Oxford City Council

Application under S.73 to vary the approved drawings for the site.

Prior approval for demolition of existing three storey office building (Use Class E) and erection of four storey building to provide 20no. flats (Use Class C3) and provision of bin stores. This application is assessed solely in respect of transport and highway impacts; contamination risks; flooding risks; design; external appearance; provision of adequate natural light; amenity; impacts of noise from commercial premises; impact on business and new residents of increase in residential use in the area; impact on heritage and archaeology; the method of demolition; landscaping; and air traffic and defence asset impacts (amended plans). 244 Barns Road Oxford Oxfordshire OX4 3RW

Application Ref. 23/00623/VAR (a variation to prior approval 21/01539/DDW56)

E4  
North

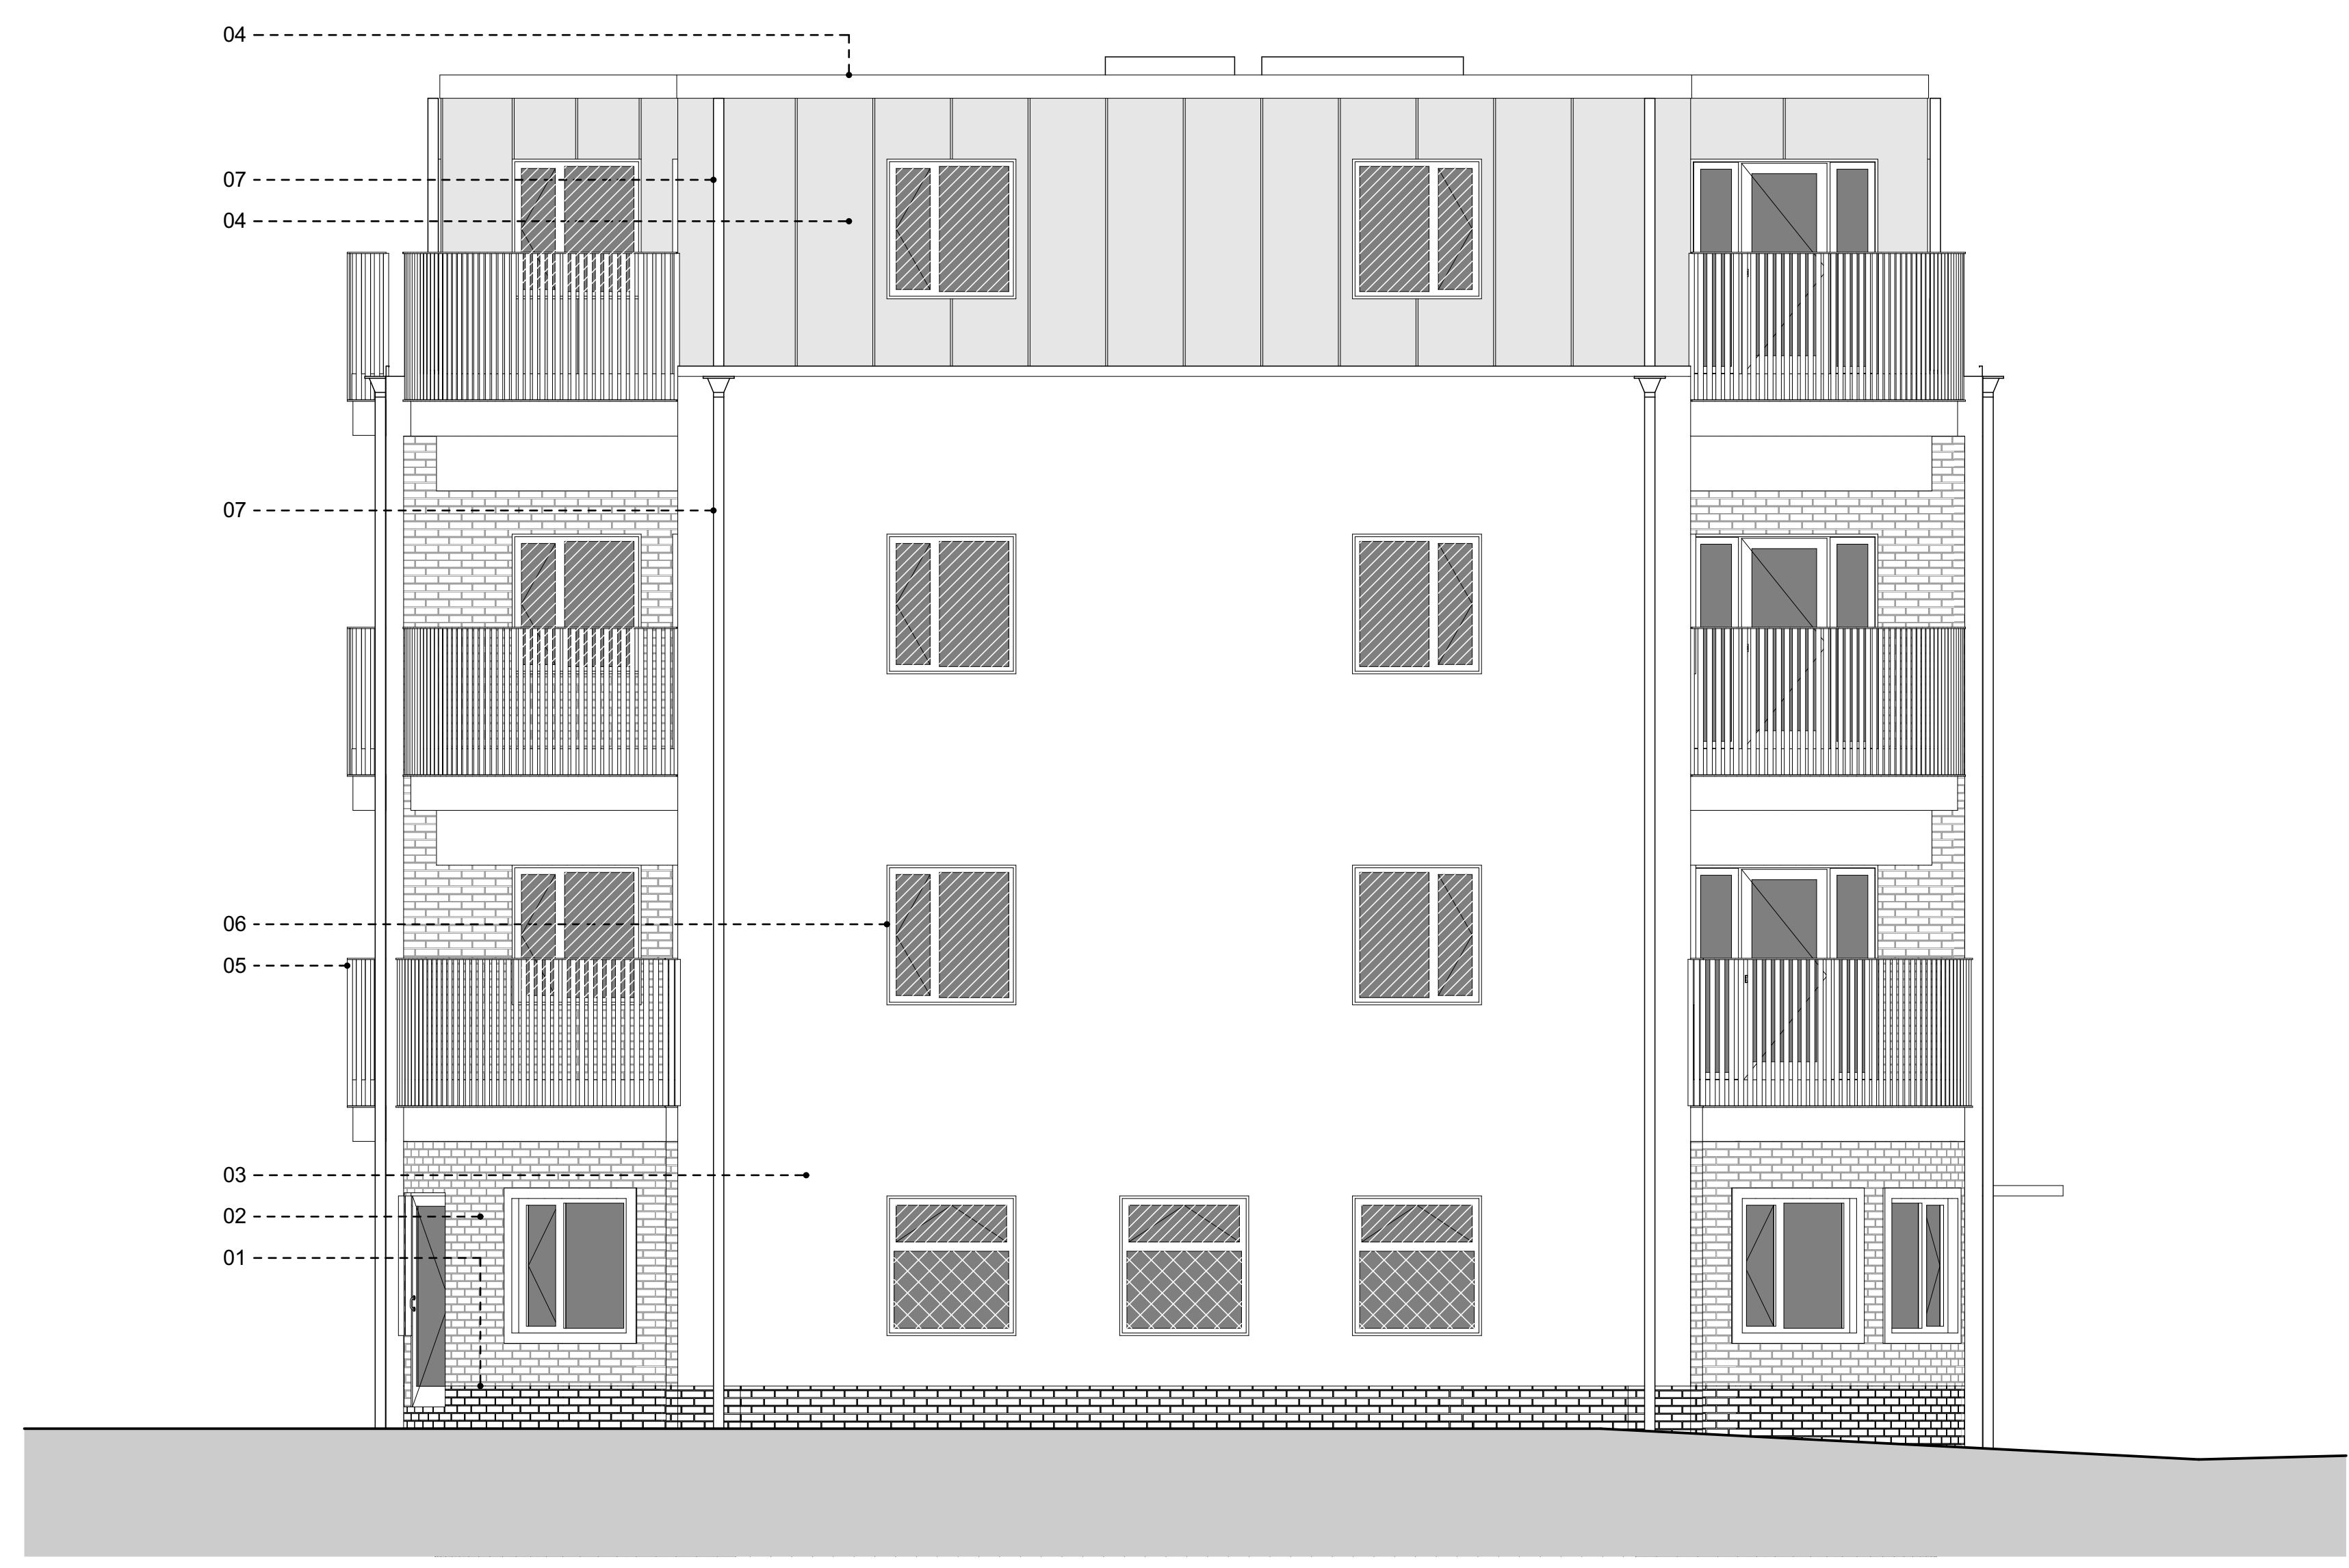
Ground floor corner terrace east: railings removed door replace by window;
Ground floor corner west: windows added
First, second and third floor corner balconies east: door replaced by window; and
First, second and third floor corner balconies west: window replaced door.
